**Consultation Response from Alan Smith,
KC Waste Strategy (Refuse & Recycling)**

2025/93470 Castle Hall, Lee Road, Ravensthorpe, Dewsbury, WF13 3BE

Change of use of existing care home (Use Class C2) to 11 self-contained residential flats (Use Class C3), including internal alterations

Responding Ref: WPN 25 052

Proposed Site Plan
Scale 1:150 @ A1

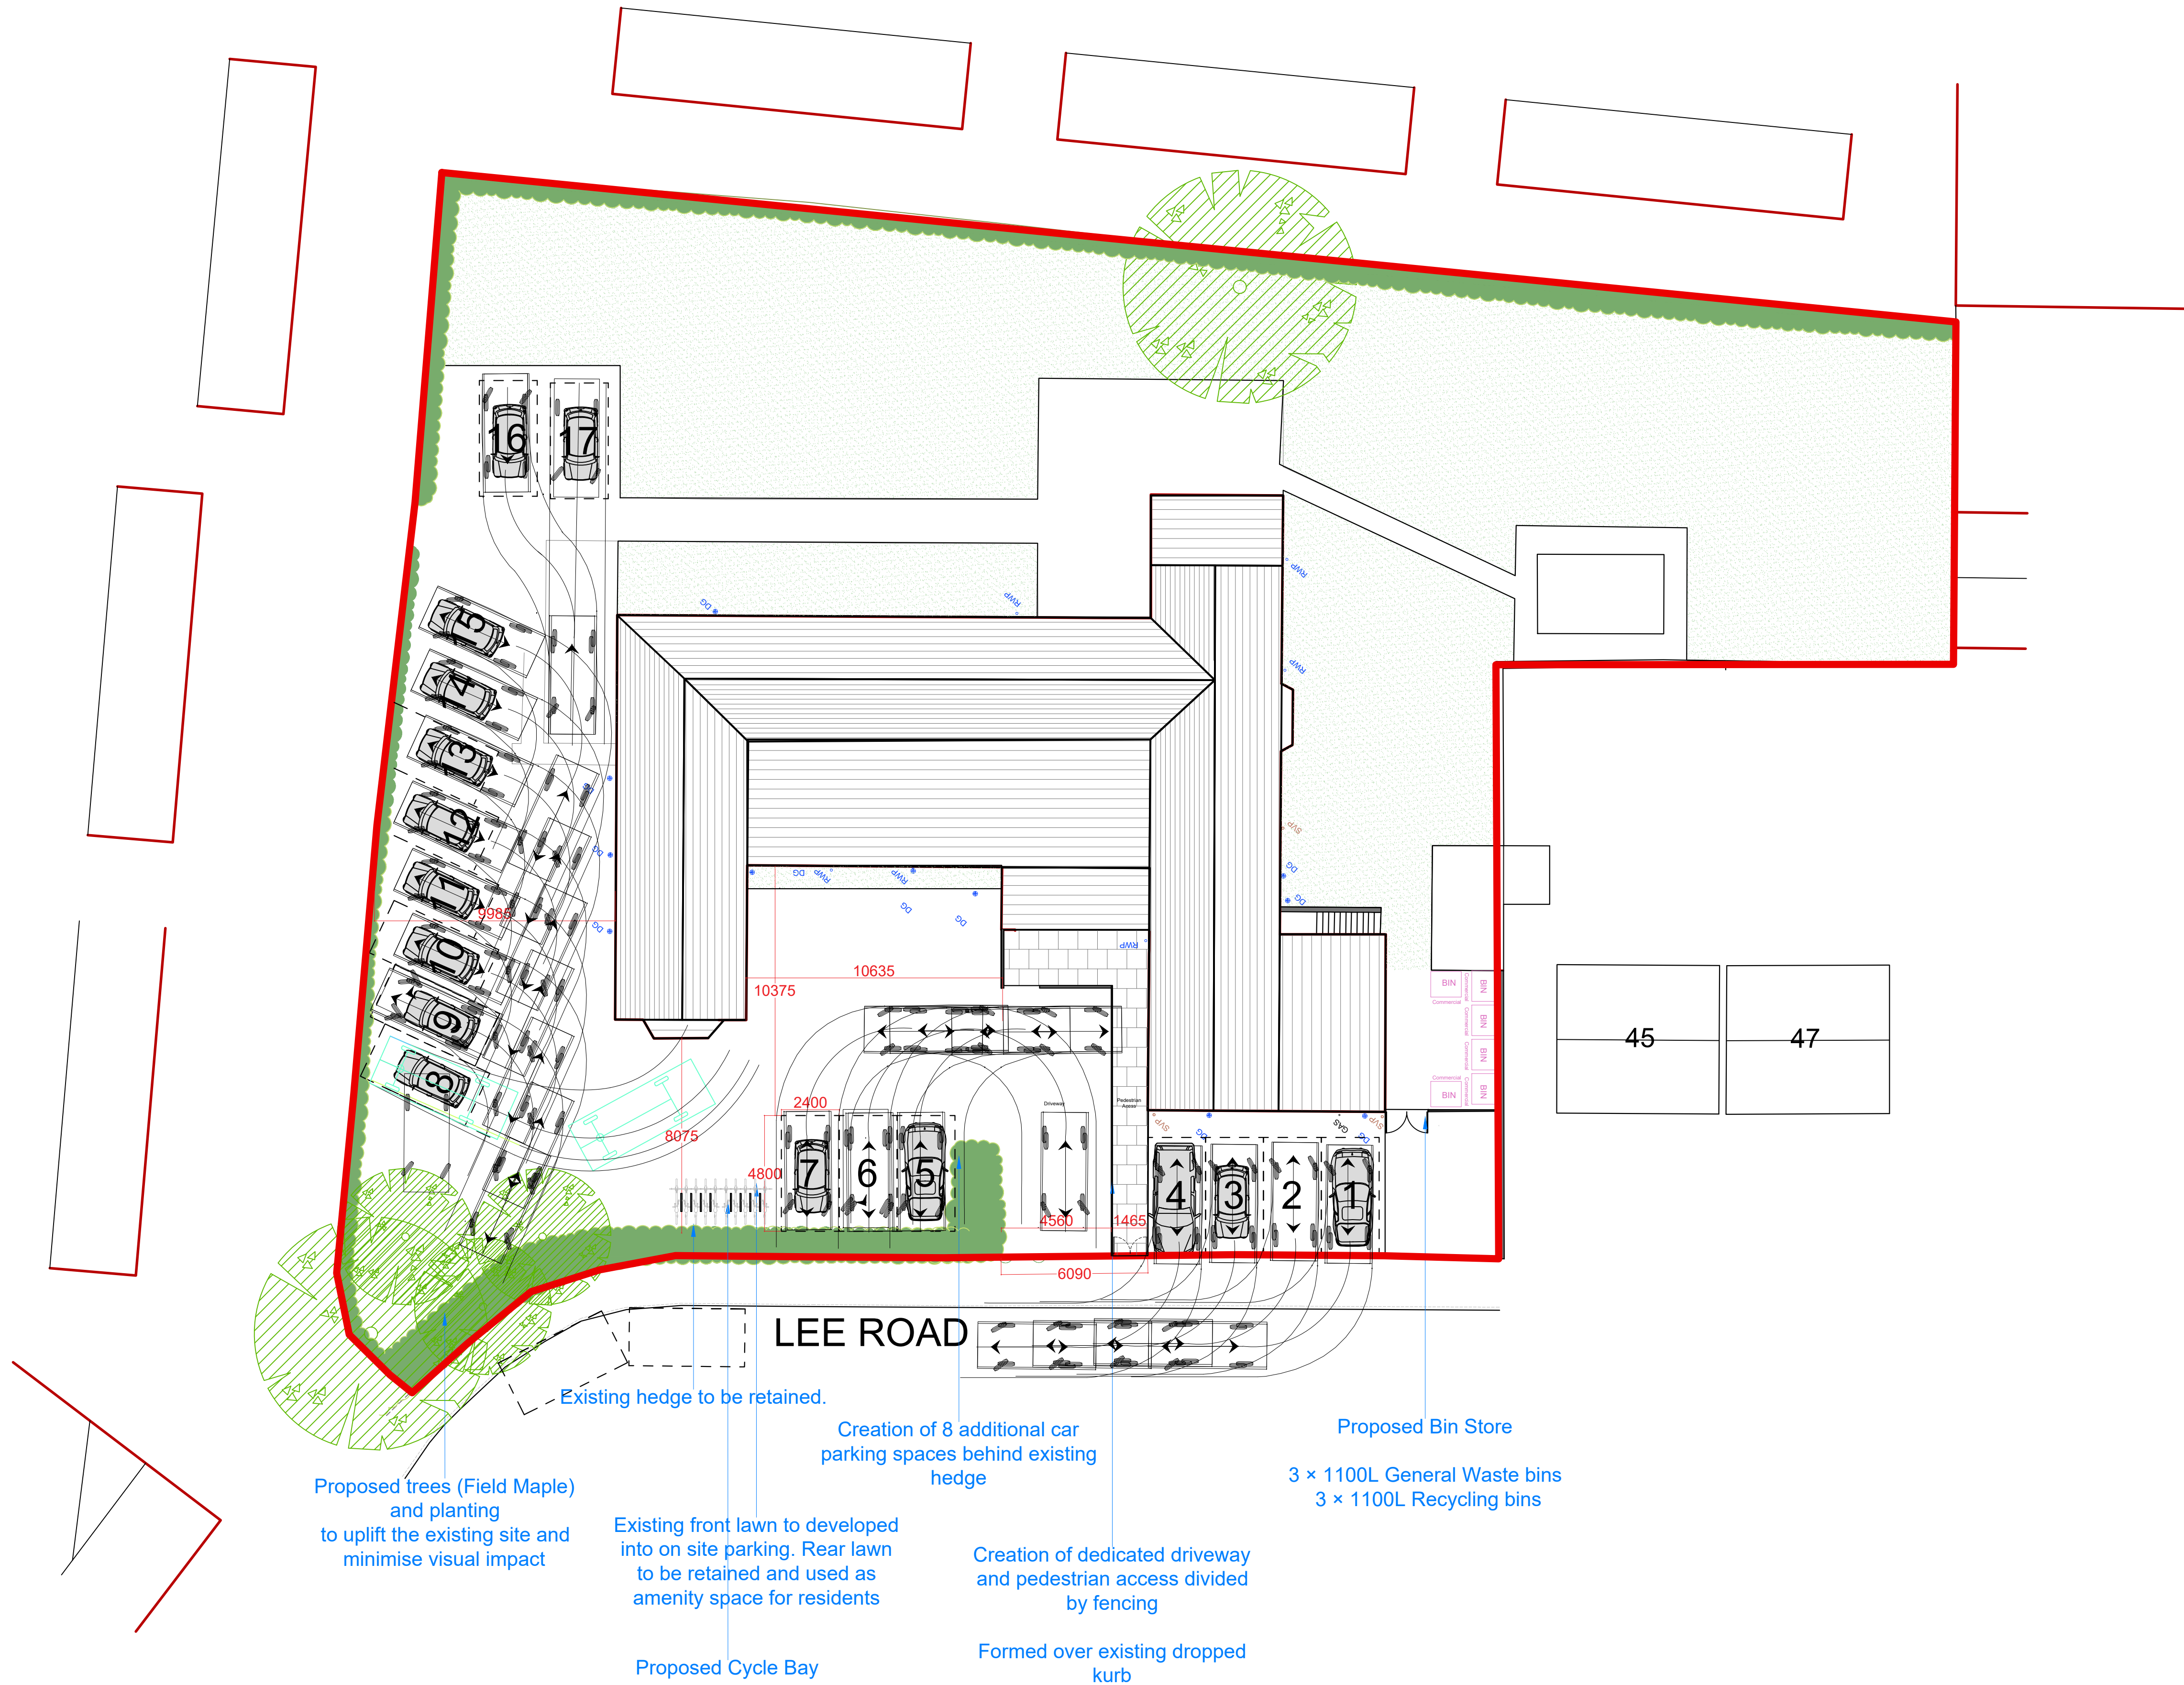
The property has 11 dwellings which means that the development will need to accommodate 11 x 180 L of waste per week = 1,980 L. Therefore, the bin store will need room to house 6 x 1,100 L bins.

- **6 x 1,100 L wheeled bins for:**
 - Residual waste – collected on alternative weeks
 - Recyclable waste – collected on alternative weeks
 - Garden waste – paid for service collected fortnightly (or future Simpler Recycling legislation provision)
- **Bin space dimensions:**
 - floor space required is 990 mm x 1375 mm per bin
- **Bin storage location:**
 - Must not obstruct highways or driveways
 - Be in rear gardens, gated access must be secure and wide enough for bins to pass through
 - No gradients steeper than 1:12 or steps
 - Must not be obstructed by parked cars
- **Composting:**
 - As the properties have a garden the developer is encouraged to provide compost bins to help better meet the council's 'clean and green' objectives for waste reduction

- Must be shown on a layout plan for all properties
- No gradients steeper than 1:12 or steps from storage area to BCP
- Located adjacent to an adoptable highway
- Solid surface required, resistant to constant wear and tear
- The maximum drag out distance from bin storage area to BCP is 25m (BS5906:2005)

- Temporary BCPs may be needed for early occupiers whilst site is being built (likely collection area would be adjacent to Lee Road)
- Access to the bin store must not be blocked with parked cars, details of how cars will be stopped from parking in front of the bin store is required

- **Pre-Occupation Waste Strategy**
Prior to commencement the developer must submit for approval details for bin storage, screening, BCPs, RCV access and how cars will be stopped from parking in front of the bin store. The approved details shall be provided before first occupation and shall be so retained thereafter.
- **Bin Store maintenance**
Before development commences, details of the management and maintenance of communal refuse storage areas by a designated private management company shall be submitted to and approved by the Local Planning Authority. The approved details shall be provided before first occupation and shall be so retained thereafter.
